From: [Grant, David](#)
To: [_planningadvice](#)
Subject: FW: 6 Broadway H02-1185-21
Date: 17 January 2022 18:37:58

From: Paul Sharman <paulsharman1@btinternet.com>
Sent: 17 January 2022 10:23
To: Grant, David <dgrant@sholland.gov.uk>
Cc: 'Lara Manton' <Lara@ljmbookkeeping.co.uk>; Lara Manton <ljmbooks@hotmail.co.uk>
Subject: RE: 6 Broadway H02-1185-21

From: Grant, David [<mailto:dgrant@sholland.gov.uk>]
Sent: 16 January 2022 21:33
To: paulsharman1@btinternet.com
Subject: 6 Broadway H02-1185-21

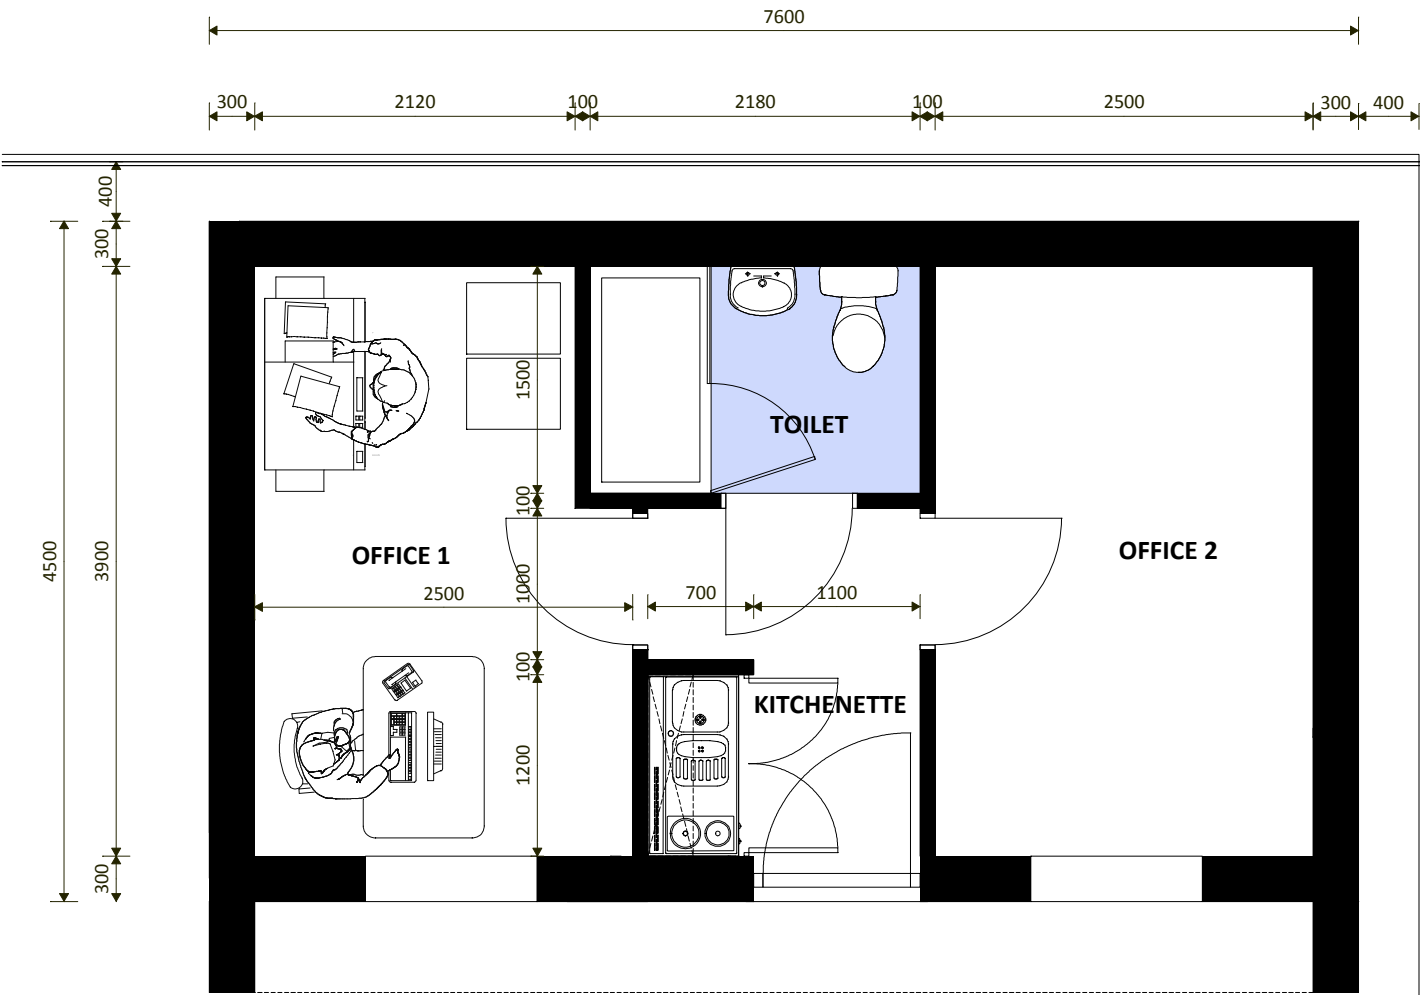
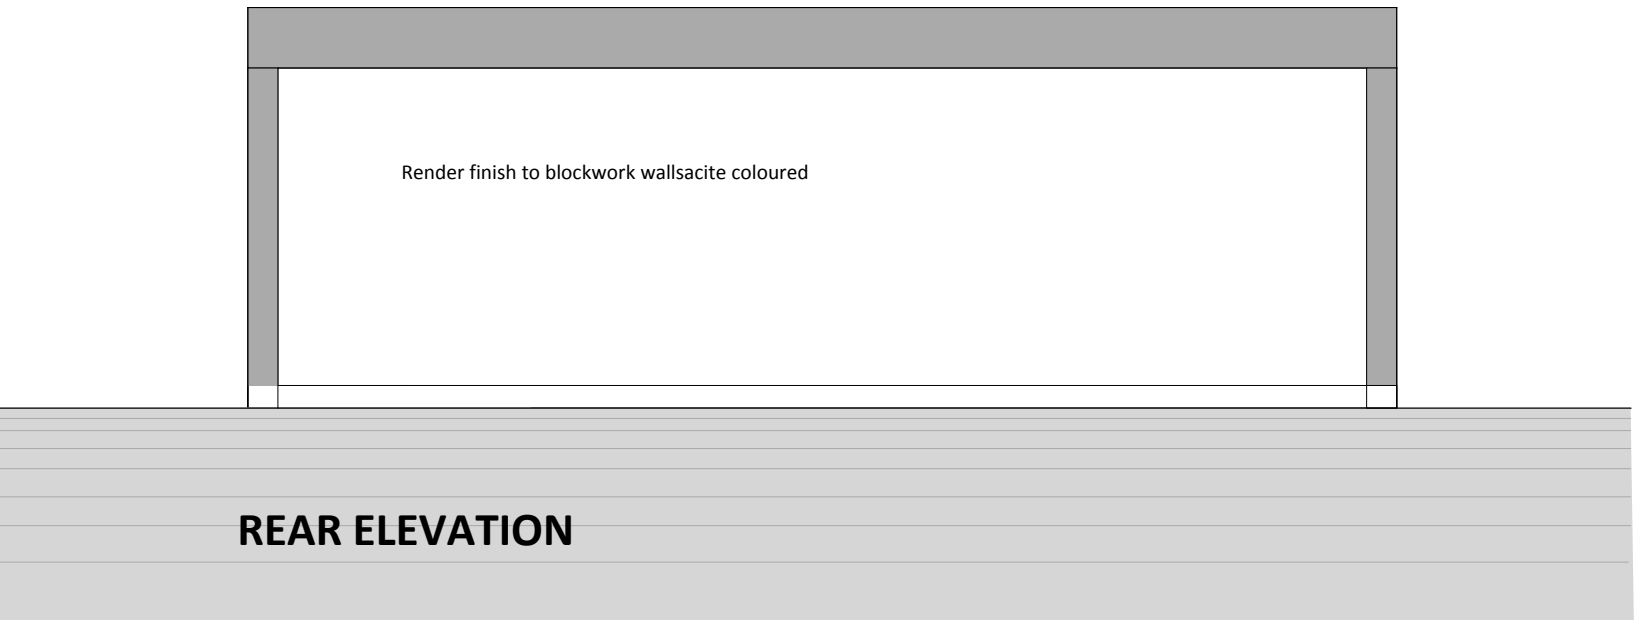
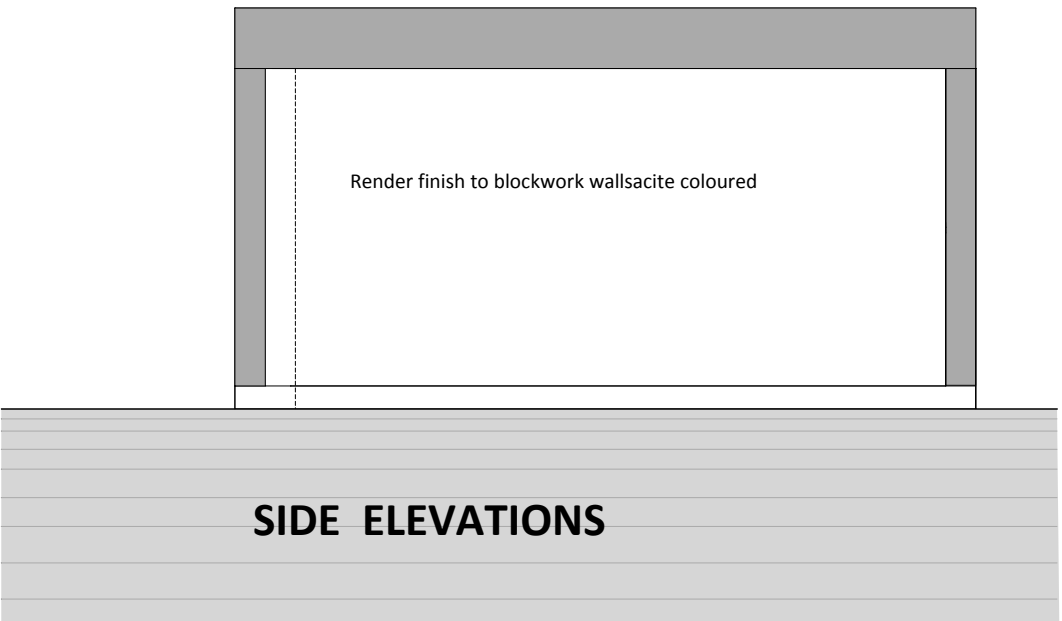
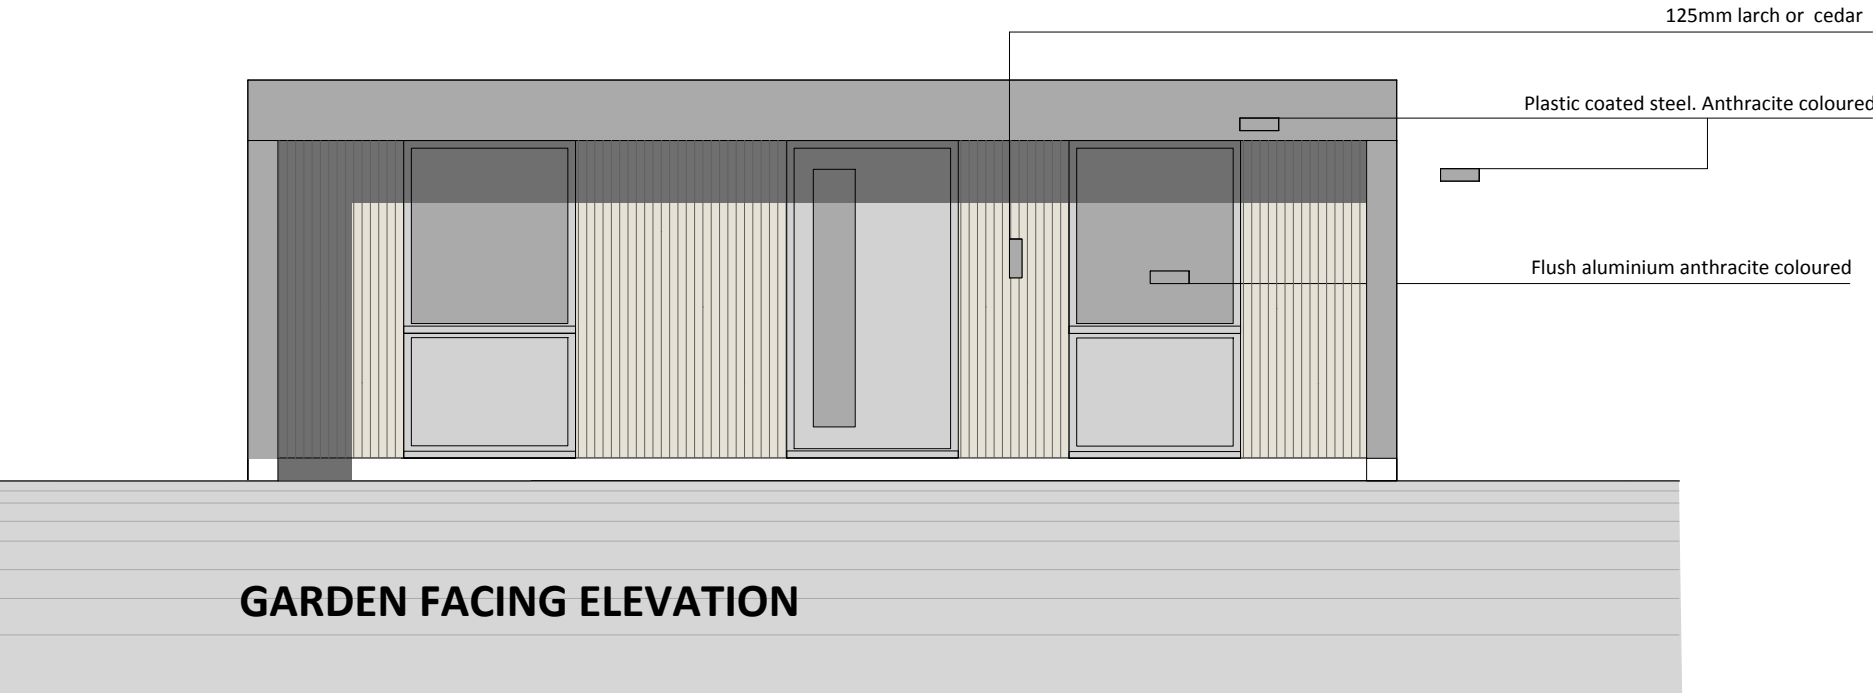
- Will the four proposed offices, two in the dwelling, two in the annexe, be solely for use by the residents of the property?
- What will the colour of the render for the annexe be? The plans state wallsacite but I cannot find any details of this colour.
- Please confirm whether the wood panelling is to be larch or cedar. Unless you are happy for this matter to be conditioned?
- What will the colour of the render for the extended dwelling be? Please state unless you are happy for this matter to be conditioned?

The colour of the render will be White or Cream

The wood panelling will be Cedar which will be allowed to weather naturally

The colour of the extended area will be as eventually chosen for the front. ie White or Cream.
